Charlotte Department of Transportation

Memorandum

Date: August 25, 2008

Subject: Rezoning Petition 08-140: Located on the east side of Park Road
between Sharon Road and Wolfe Ridge Road

Existing Conditions

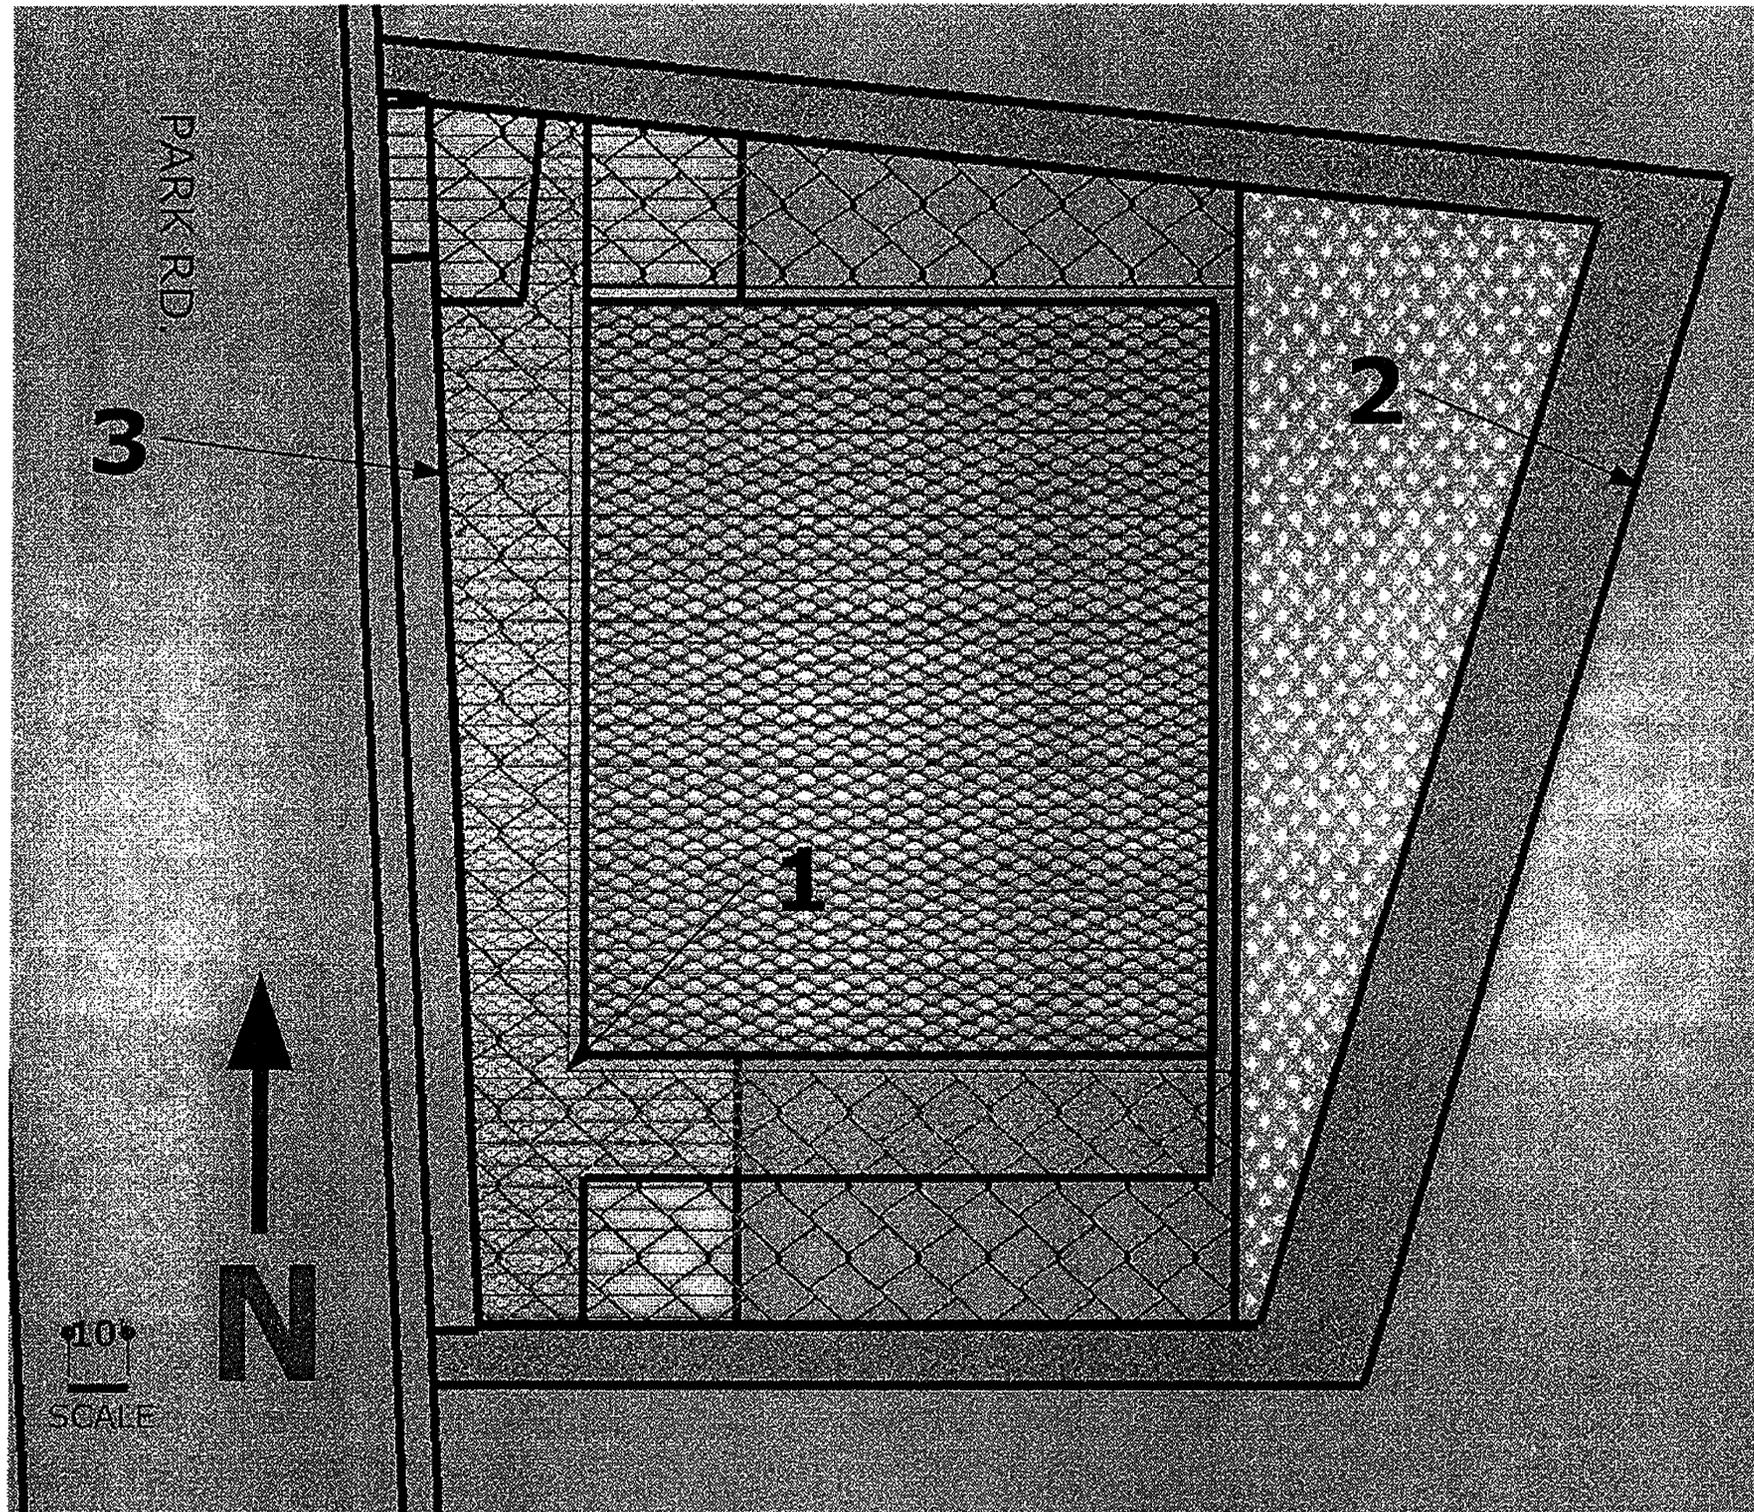
1. Due to the proposed density for this site and deficiency of connectivity with the surrounding area, we request that a new public street be provided along the northern property boundary of the site, stubbing to the eastern property boundary. Access to the site will be from a driveway to this new public street.
2. The requested public street needs to be designed as a Local Residential Street – Wide in accordance with the Urban Street Design Guidelines (USDG). This typical cross-section includes a 35-foot back-of-curb width with a 20-foot wide two-way mixed vehicle zone between two 7-foot on-street recessed parking lanes, as well as 8-foot planting strips and 6-foot sidewalks.

3. The site plan should acknowledge and note that in the urban residential zoning district building setbacks are required to be measured from the back of either an existing or future curb-line. CDOT has determined that the proposed curb-line for Park Road will be located 4 feet behind the existing curb-line. This should be noted and illustrated on the conditional site plan.

Park Road is a major thoroughfare requiring a minimum of 100 feet of right-of-way. The developer/petitioner should convey right-of-way in fee simple title to meet this requirement, measuring 50 feet from the centerline of the roadway.

Adequate sight triangles must be reserved at the existing/proposed street entrance(s). Two 35' x 35' sight triangles are required for the entrance(s) to meet requirements. All proposed trees, berms, walls, fences, and/or identification signs must not interfere with sight distance at the entrance(s). Such items should be identified on the site plan.

CDOT Parking Schematic

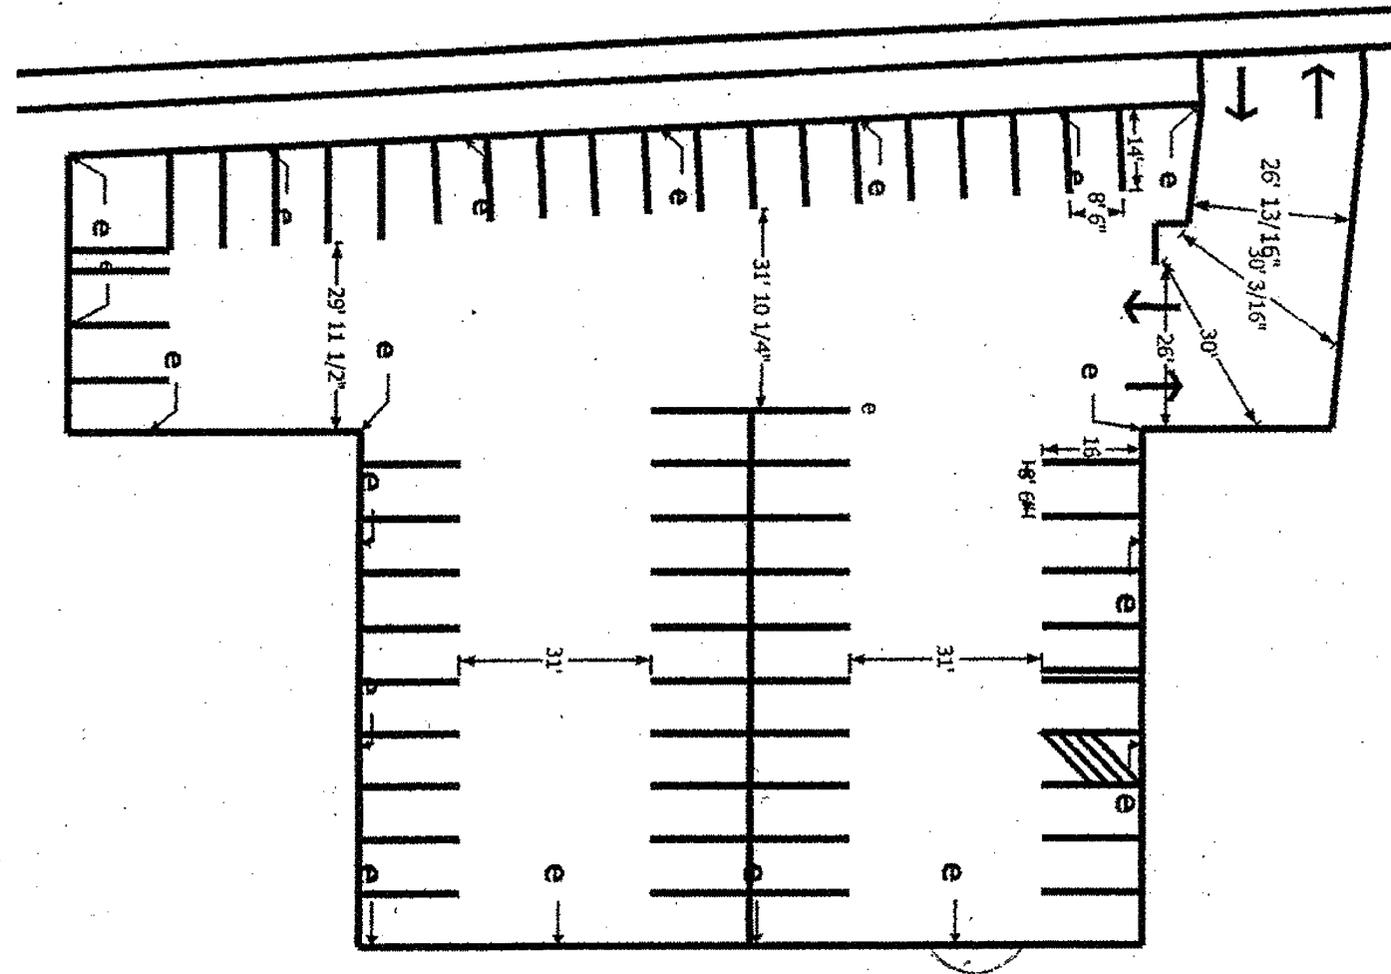
- Meet applicable standards in the Charlotte Land Development Standards Manual (latest revision).
- Dimension width of the existing and proposed driveways.
- Indicate the locations and widths of all adjacent and opposing driveways.
- Indicate typical parking module dimensions.
- Include a parking summary with figures for the numbers of parking spaces required and provided.
- Directional wheelchair ramps (two per corner) should be provided at all intersections of public and private streets.
